10-19-2013

Comments CU 23 00004 Guest Ranch

To Jamey Ayling

FOWLER CREEK GUEST RANCH
EXHIBIT 12
EMERGENCY INGRESS AND EGRESS PLAN

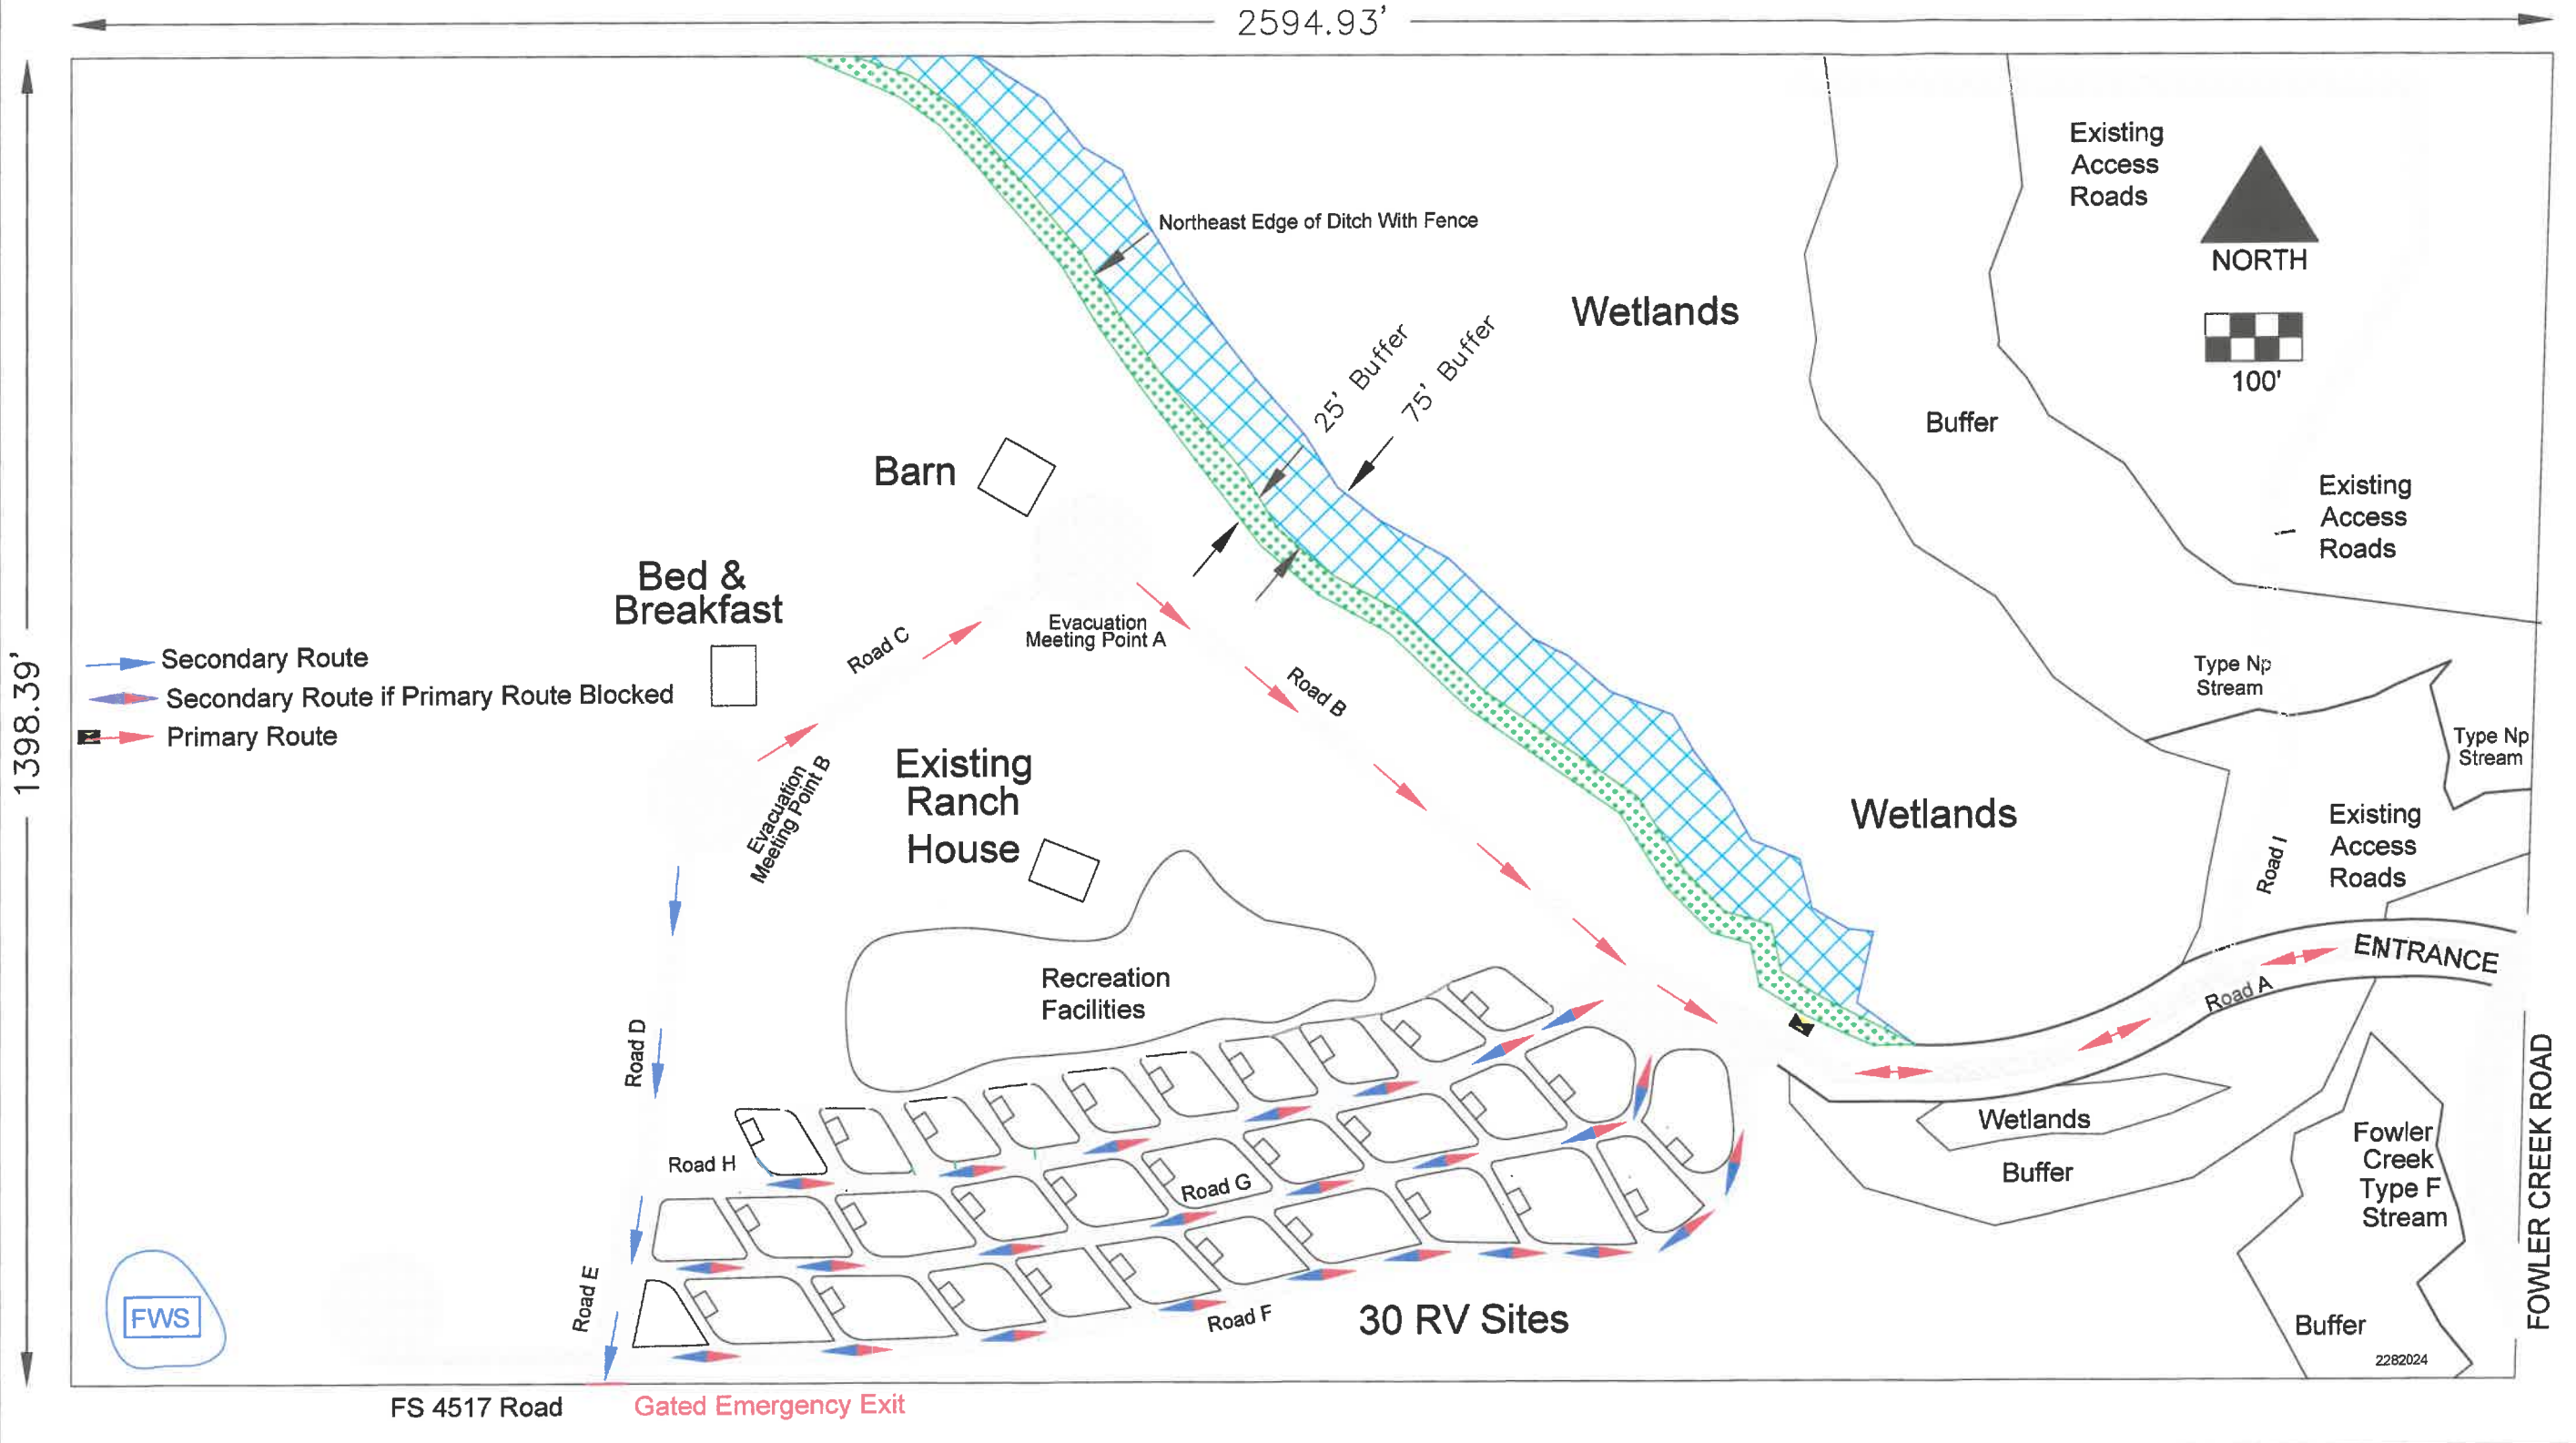
**Traffic Flow**: Site map (Exhibit 16) indicates Ranch entrance is off Fowler Creek Rd (west of FSR 4517) and ranch Exit is onto FSR 4517; maybe 1/3<sup>rd</sup> of mile south, up hill from Fowler Creek Rd. Does that indicate the traffic on site is one-way? 100% in on Fowler Creek and 100% out via FS Road 4517?

Exhibit 12 Traffic basically states 10% of traffic moving east on Westside Road. There may be 5% of that 10% that would move to the south on FS Road 4517. If that is the case; where would that 5% go? Doesn't 100% of traffic enter Ranch off Fowler Creek Road and exist Ranch via FS R4517? Site Map is not clear on this. Many if not most camp grounds have one way traffic. As site map seems to indicate.

Is the USFS aware of this potential added traffic volume to the beginning to FSR 4517? Who will maintain that road? Shouldn't that portion of FSR4517 be upgraded to meet county needs and safety standards, now that so many RV's may be traveling on it. Surface conditions, width, heavy brush all seem unsafe, especially during emergency situations. Fire vehicles could be greatly impeded.
